Mr Raymond Cole,
Case Officer
Arun District Council
Arun Civic Centre
Maltravers Road
Littlehampton
West Sussex
BN17 5LF

17th July 2020

F/4/20/OUT outline planning application (with all matters reserved except for access) for the development of up to 1,500 dwellings, 60-bed care home, B1 employment floorspace, local centre, land for a two-form entry primary school etc Land at Ford Airfield, Ford.

Figure 35: Parameter Plan - Access and Movement

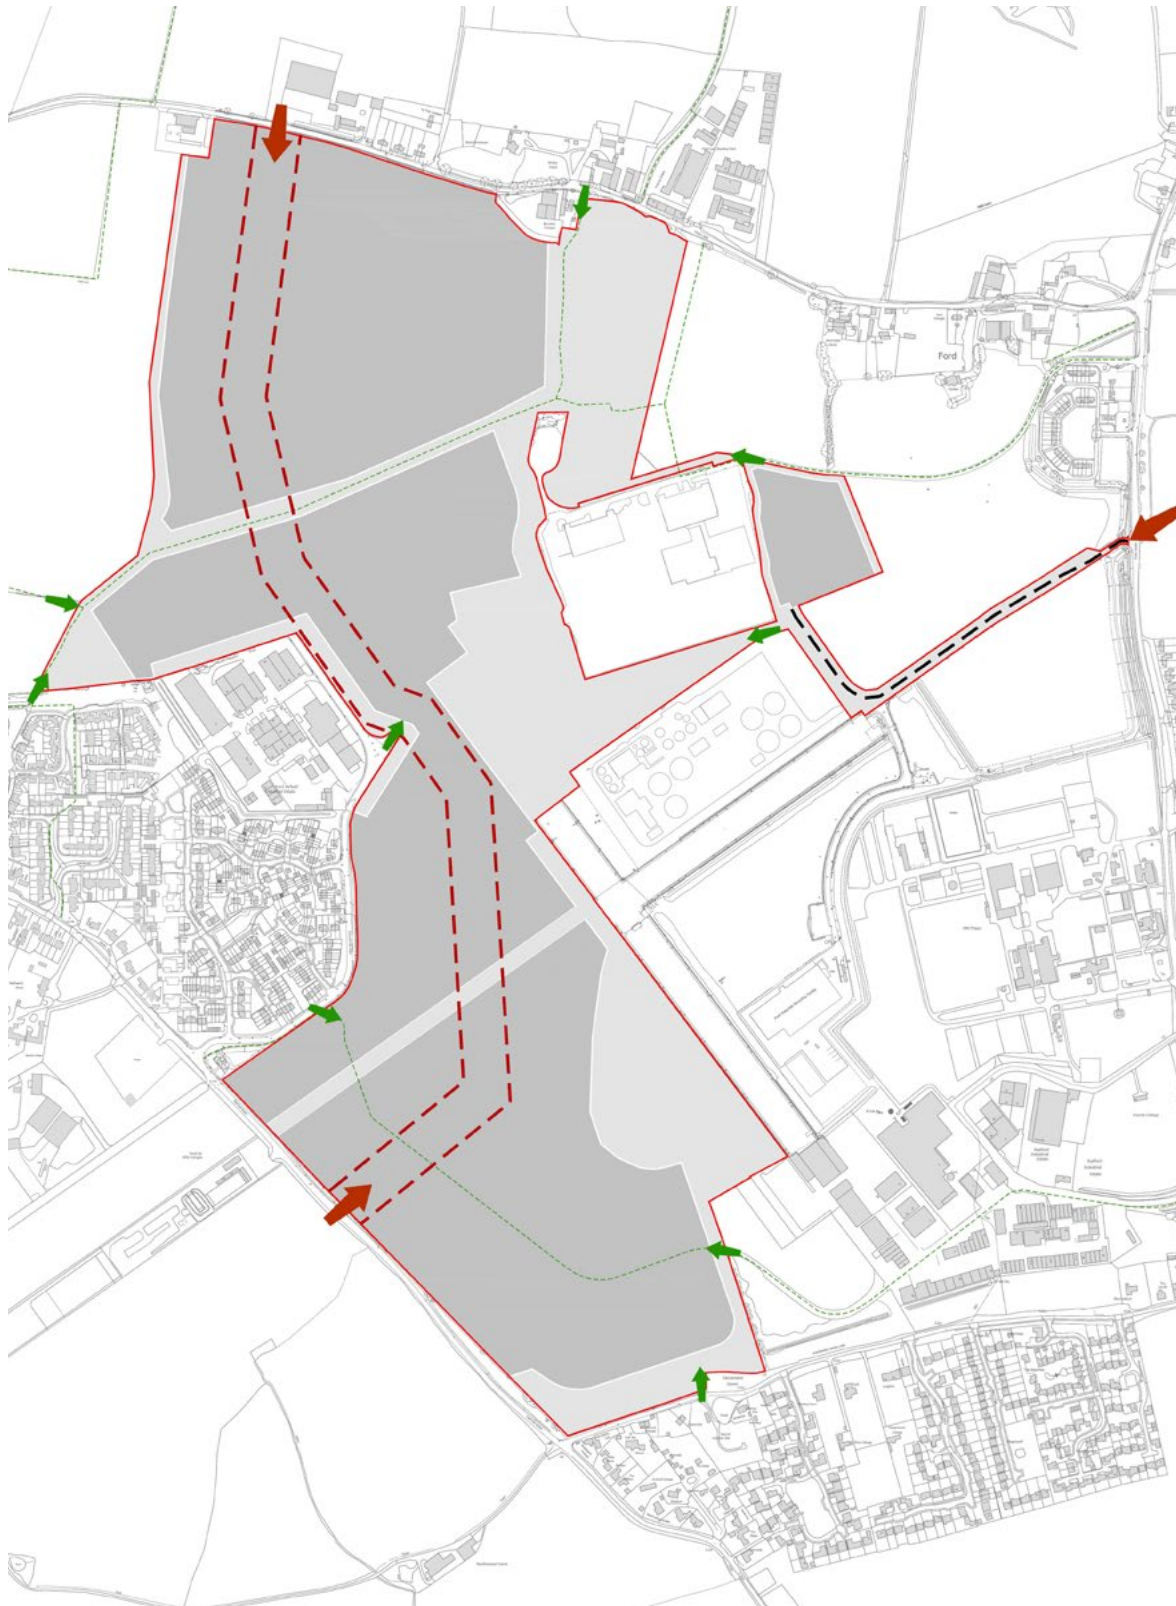
There are, however, some outputs from the workshop which have not been reflected in the proposed design. The proposed plans a spine road going north-south through the site. There were very strong views voiced at the workshop that there should not be a vehicular north-south route through the development site. Participants were keen to avoid creating a rat run through the site - *"Don't put a main road through the middle of the site. It will divide the community."*
